**WEST SUSSEX COUNTY COUNCIL
STRATEGIC PLANNING CONSULTATION**

SUBJECT: CM/7/17/PL - The Old Piggery, The Street, Climping, West Sussex, BN17 5RG

Change of use of permitted office building (B1 Business) to 4 No. visitor residential accommodation units (C1 Hotels). This application affects the setting of a Listed Building.

site and roof plan 1:200@A1

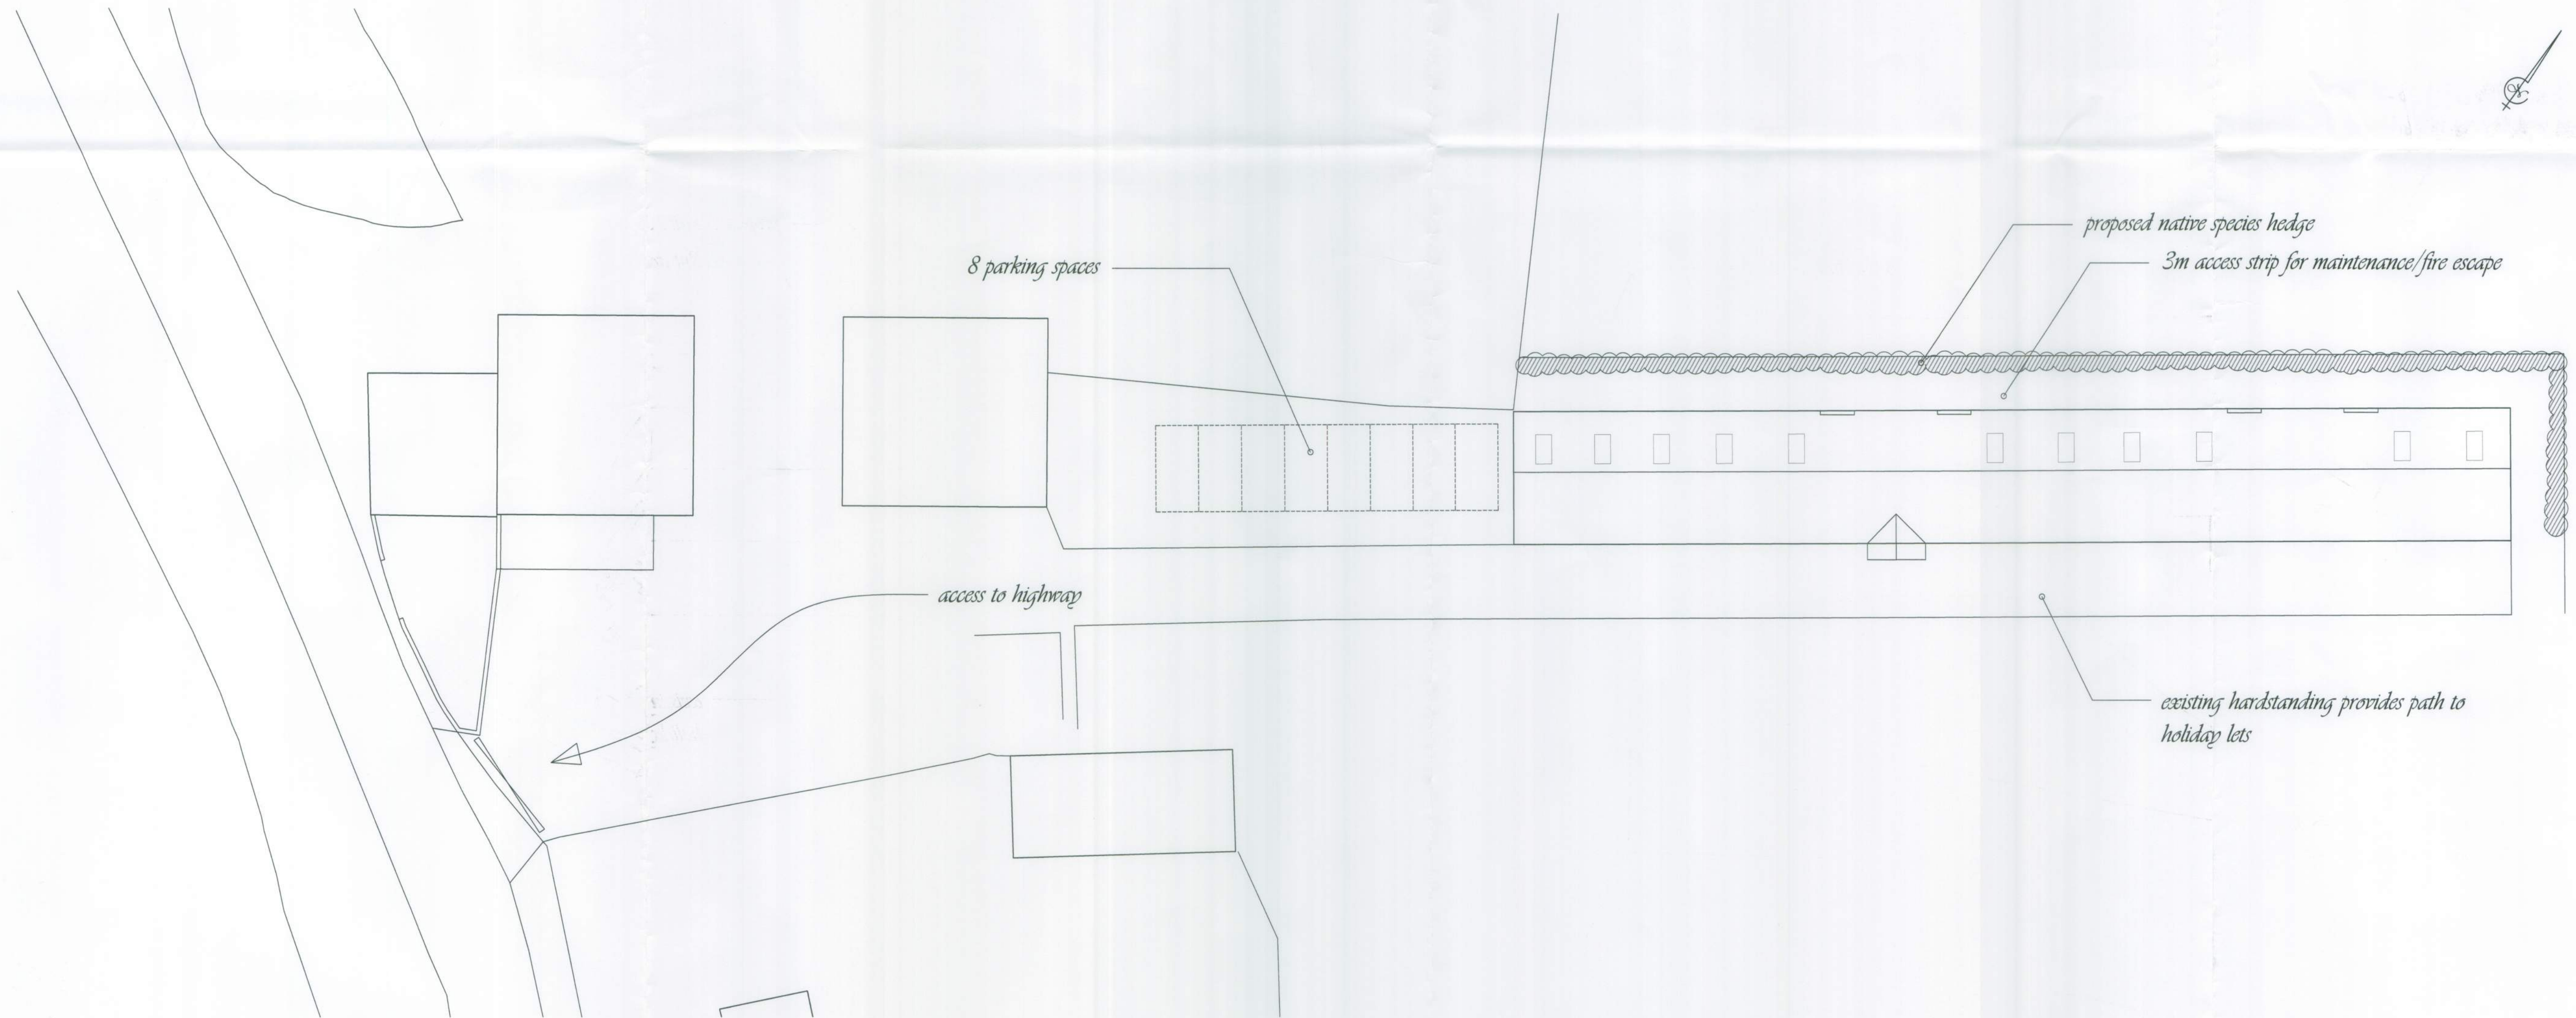
The existing vehicle crossover appears to be in a poor state of repair and we would advise that the applicant contact the WSCC Highways Local Area Engineer to discuss a licence for these access works on to the public highway to be improved. We note that the vehicle access is to be constructed of gravel. This may result in material being dispersed onto the public highway affecting the surface of the road. The applicant should provide details of a gravel trap or area

of block paving, or other bound material, at the point of access onto The Street (on land within the applicant's control; not within the publicly maintained highway).

Under WSCC Car Parking Standards the Local Highway Authority (LHA) acknowledge that 385 sqm of B1A office space use could have attracted a maximum demand for up to 13 car parking spaces. In comparison the C1 holiday let use with eight bedrooms total could attract up to eight car parking spaces which are proposed within the confines of the site.

The LHA acknowledges that vehicular visibility in the leading direction (north-west) upon exiting the existing access is substandard. No evidence has been provided from the applicant with regard to trip generation of existing and proposed uses. They should provide this information in order to demonstrate that the proposed use will be less trip intensive than the existing considering that visibility is substandard at this existing access point.

Visibility could be improved with the clearing of vegetation and lowering/ set back of the wall. The applicant should confirm whether that land in the blue edge that would be required for this is within their ownership/ control and could demonstrate the maximum achievable visibility available to the nearside road edge.

Please ask the applicant to consider providing evidence and demonstrate that the proposed use will be less trip intensive and/ or demonstrate that improved visibility in the leading direction is achievable.
